App No: WA/75/17/PL

Address: Land adjacent to Sunny Corner Copse Lane Walberton BN18 0QH

Proposal: 9 No. dwellings with associated car parking, bin storage & landscaping & creation of new access road from existing access onto West Walberton Lane. This application is a Departure from the Development Plan.

**Figure 2.** The proposed layout of the Sunny Corner development, with a red line indicating the site ownership boundary.

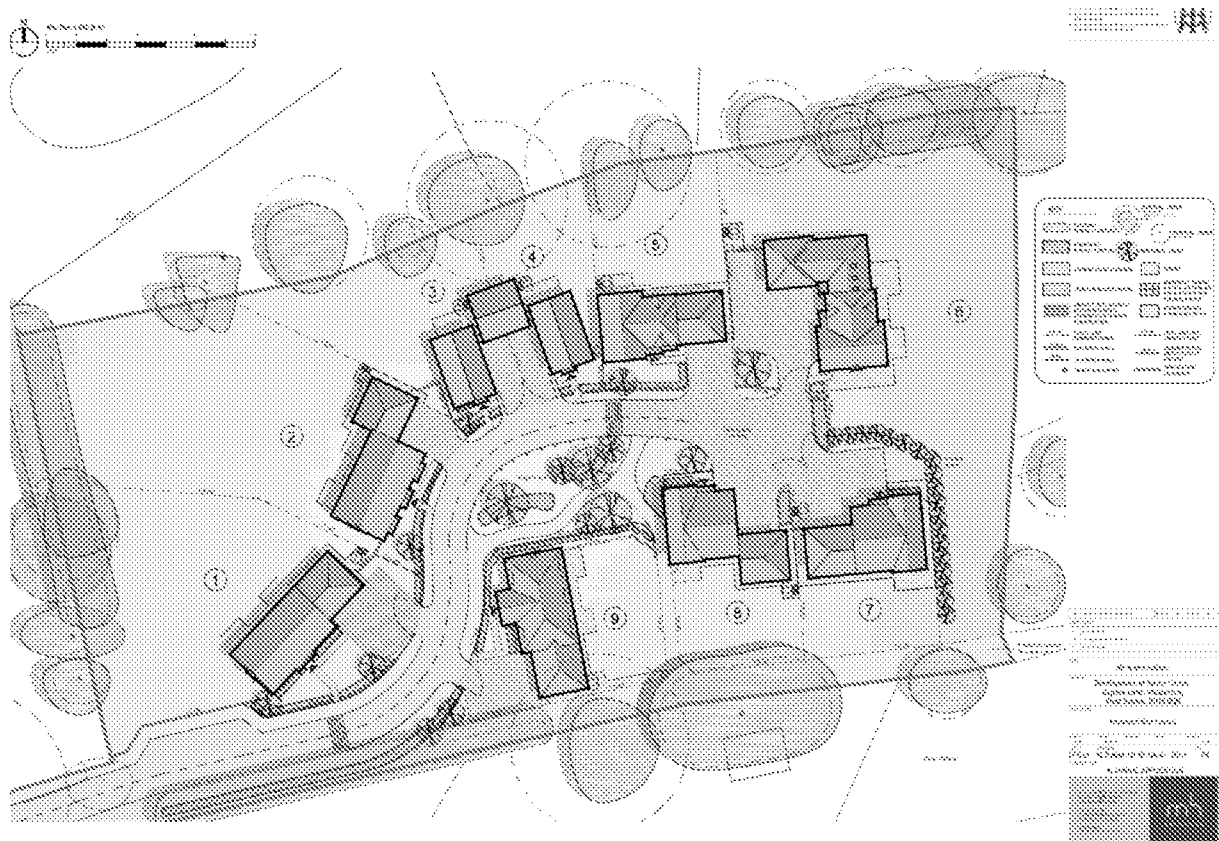
Due to the location of Ancient woodland to the site we require that a 15m buffer zone is created from the ancient woodland to ensure this area remains undisturbed. Though the ecologist has provided some justification as to why this buffer could be reduced, there is sound reasoning behind the 15m buffer zone which we require is upheld. The 15m buffer is in place to not only ensure there is no damage to the woodland, but also to ensure there is no disturbance to the species using the woodland (bats, dormice etc), it also ensures there is no light spill from development into the woodland, noise is reduced and the buffer also takes into consideration the permitted development rights that new properties would have. From looking the site and the size of each plot and garden, there is potential for the closest plots to be moved further away to ensure a 15m buffer is created.

**Figure 7.** The blue lines indicate the proposed additional planting to support existing hedgerows and the yellow line indicated the proposed new hedging.

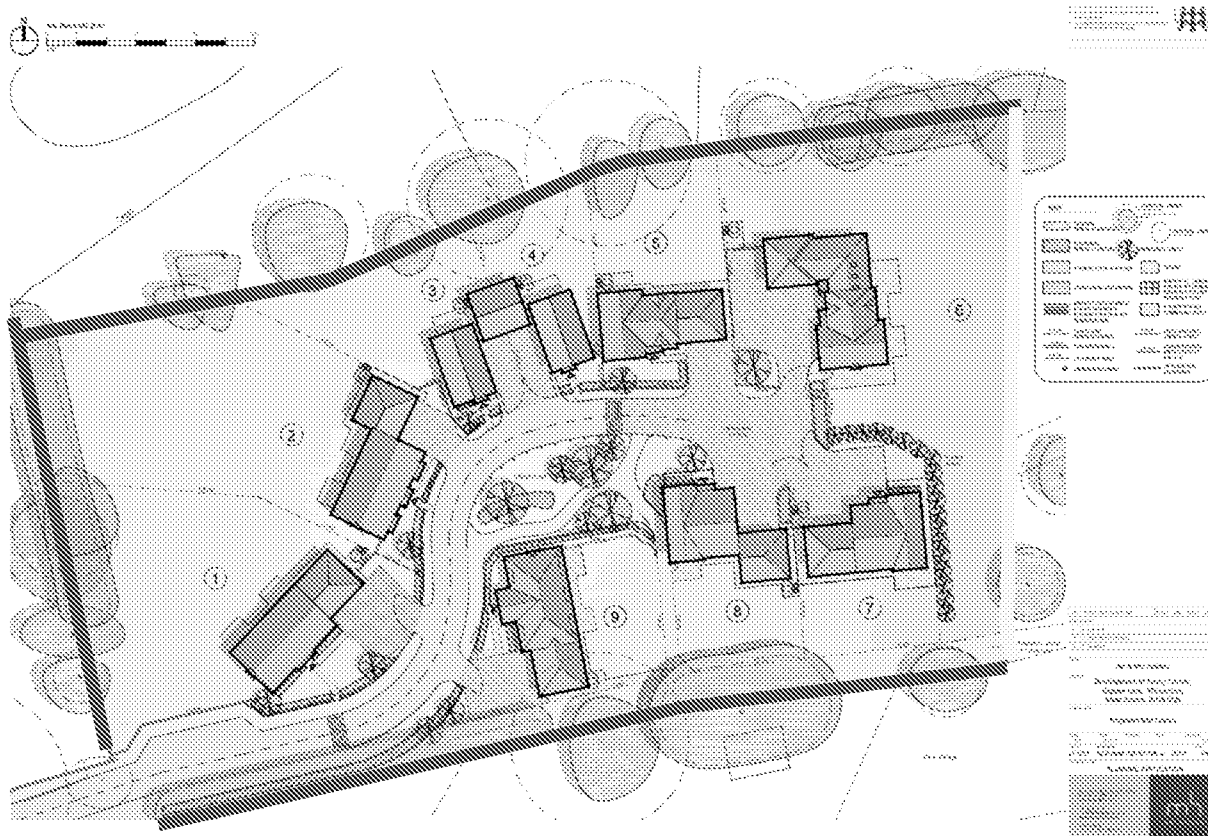
The phase two habitat surveys have found that there is a good population of dormice onsite. Though some positive mitigation has been detailed within the reports stating that new hedgerow will be planted onsite to provide new and connecting habitat for the dormice, there is a lack of information regarding how the dormice will be protected from harm during the works. We require that further information regarding the mitigation for dormice is submitted prior to determination.
